Application: BN/65/22/PL

Location: Barnham and Eastergate: Land at rear of Cedar End Eastergate Lane Eastergate PO20 3SJ

Proposal: Sever land and erection of 1 No bungalow with new vehicular access (resubmission of BN/14/22/PL). This application is a Departure from the Development Plan and is in CIL Zone 3 and is CIL Liable as new dwelling.

Holding objection due to insufficient ecological information on designated sites (SAC) and European Protected Species (bats and Hazel Dormouse).

Land r/o Cedar End, Eastergate ^ Site Plan B+W ^ 1:200@A1 ^ 1671-SYM-00-ZZ-DR-A-0207 P04

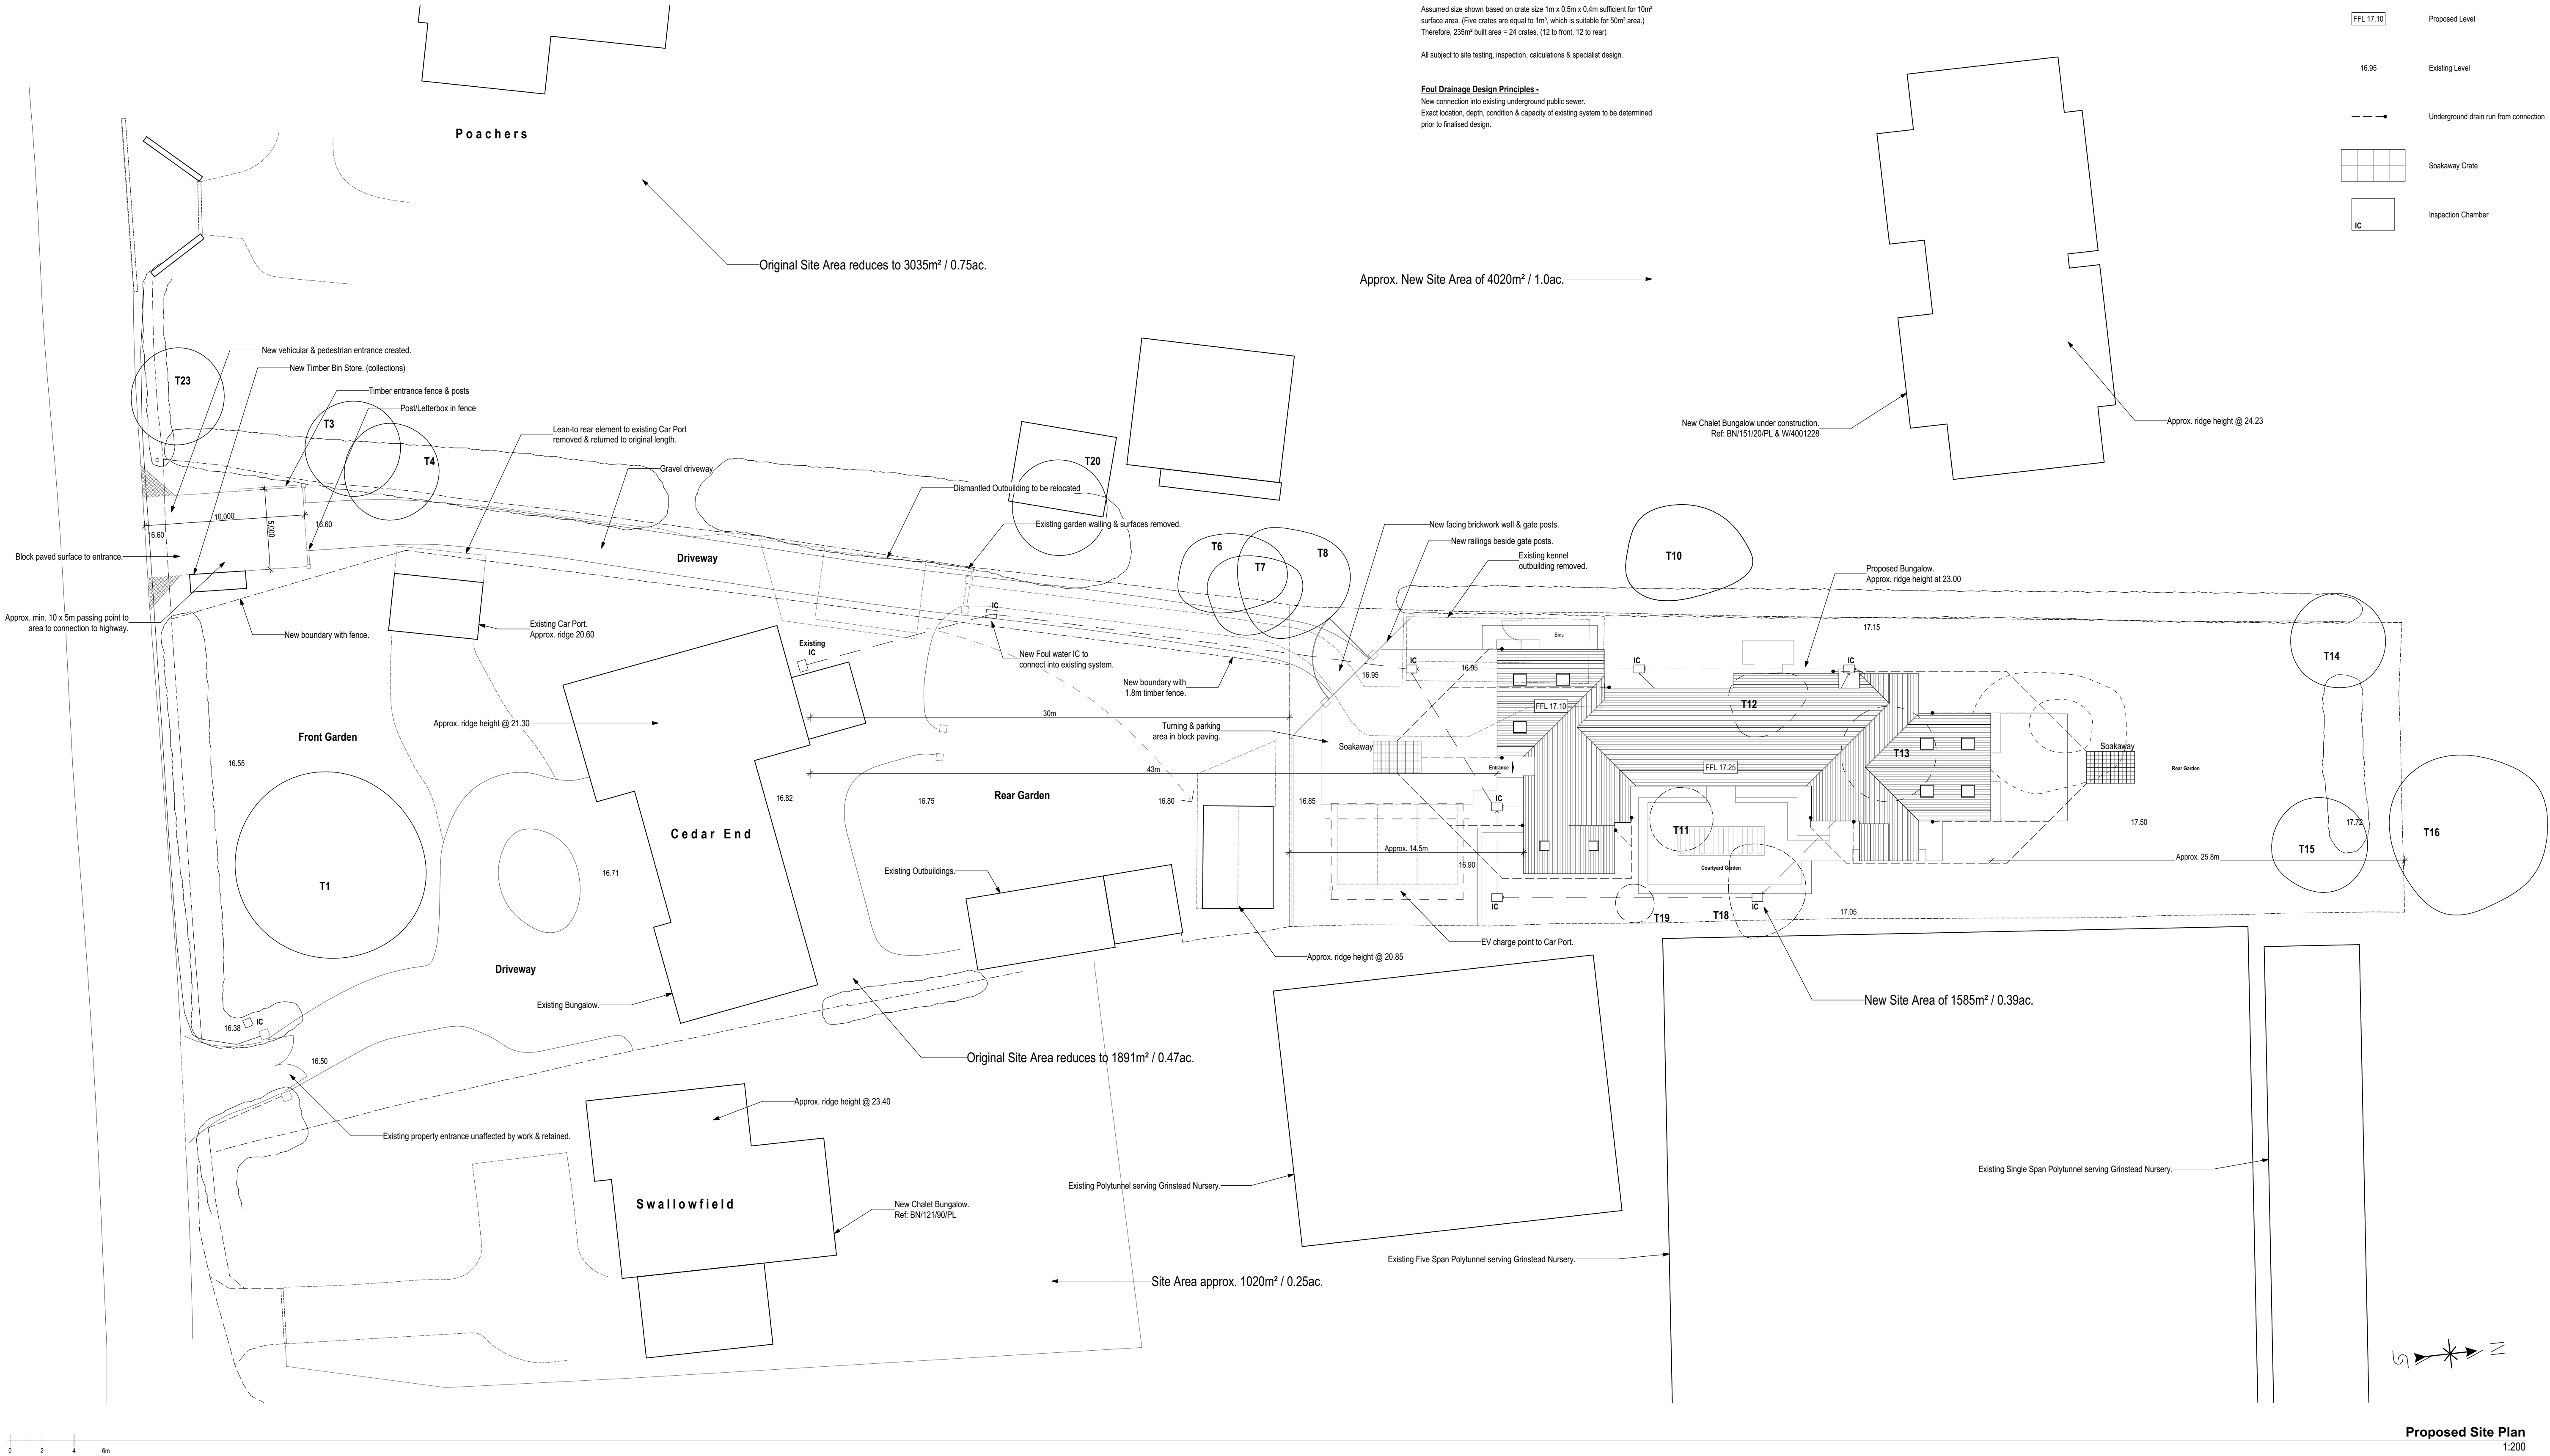
“The hedgerows on site are used by dormice for commuting and foraging and will need to be retained and enhanced. This will include having a buffer strip around the hedgerows (5m) and during construction fencing should be used to ensure this area is undisturbed. Any gaps should also be filled in using native hedge species to improve connectivity. If any works need to take place within these areas, further survey work for dormice is required. The applicant should confirm that no works will be taking place within 5m of the hedgerows onsite and a condition should be used to ensure this takes place.”

We are in agreement with the above recommendations relating to appropriate Dormice mitigation and enhancement measures and recommend this guidance is followed. The LPA therefore needs confirmation that the above measures have been embedded into the development to avoid impacts on Dormice.
